Department of Transportation

August 12, 2022

RE: Venetucci Farms Business Event Center
Special Use EA 212/AL2115

Figure 1
SITE LOCATION

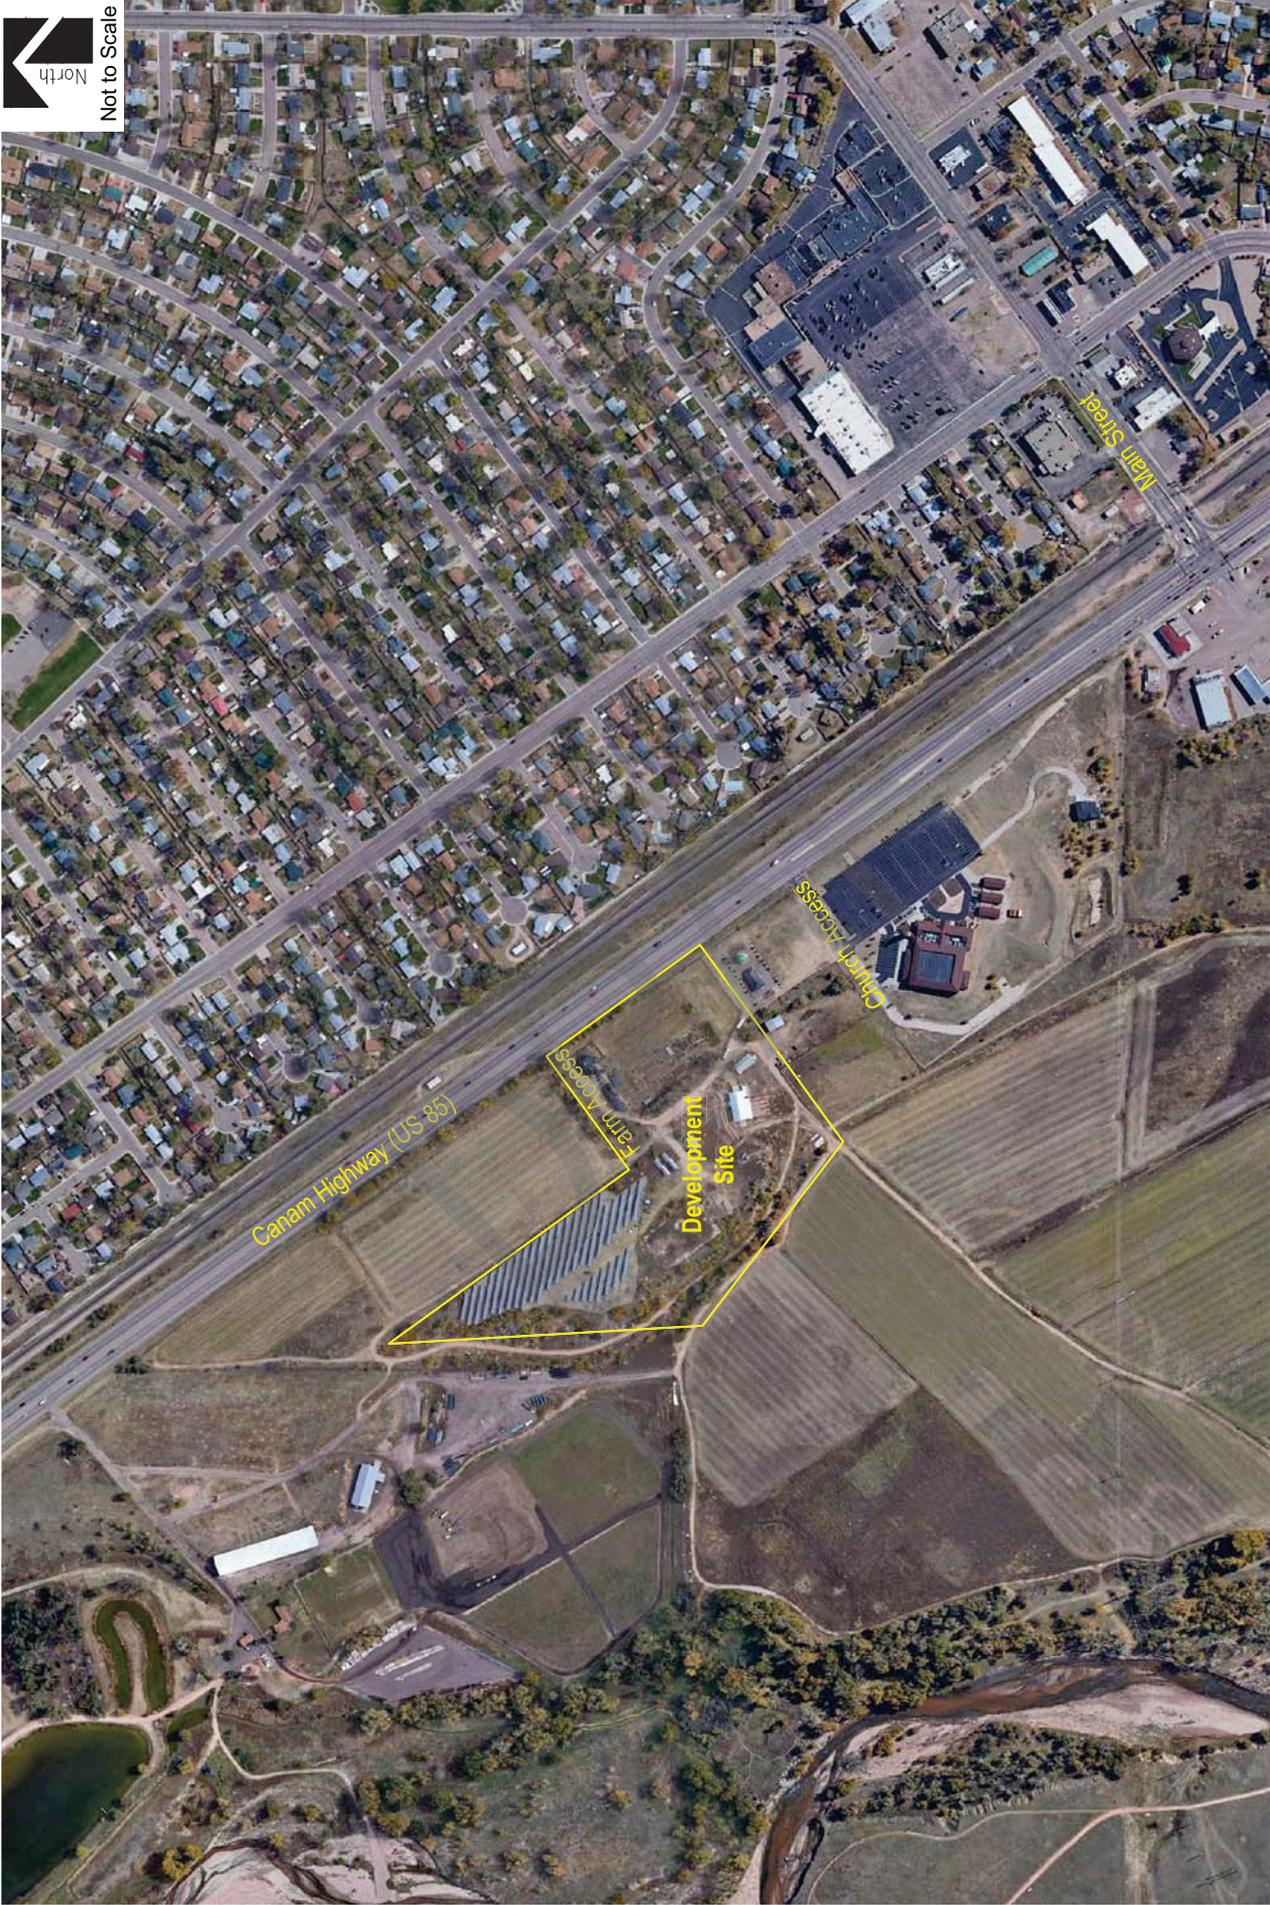
- The Letter of Intent states that the Church Access is used by Venetucci Farms via informal agreement. The Letter of Intent and the Traffic Memo refer to both the church driveway connection to the highway and the farm road connection to the church driveway as Church Access. To clarify, the farm road connection to the church driveway will be gated, NOT the church driveway, as it will remain open as currently permitted. The farm road connection to the church driveway may only be used for emergency access. A formal agreement is needed for the State to shared access to the highway for two adjacent properties if desired in the future.

- As stated in the Traffic Memo, dated May 25, 2022, a right turn acceleration lane is required at the Farm Access overlapping with the right turn deceleration lane for the Church Access making a continuous auxiliary lane between the two accesses.

- As stated in the Traffic Memo, dated May 25, 2022, a right turn deceleration lane is required at the Farm Access.
- As stated in the Traffic Memo, dated May 25, 2022, the TWLTL shall be eliminated and restriped with a left turn deceleration for the Farm Access. Furthermore, the TWLTL shall

be eliminated from the Church Access to east of the Farm Access by striping a double yellow median with left turn acceleration lanes for both the Farm Access and Church Access as well as the left turn deceleration for the Farm Access.
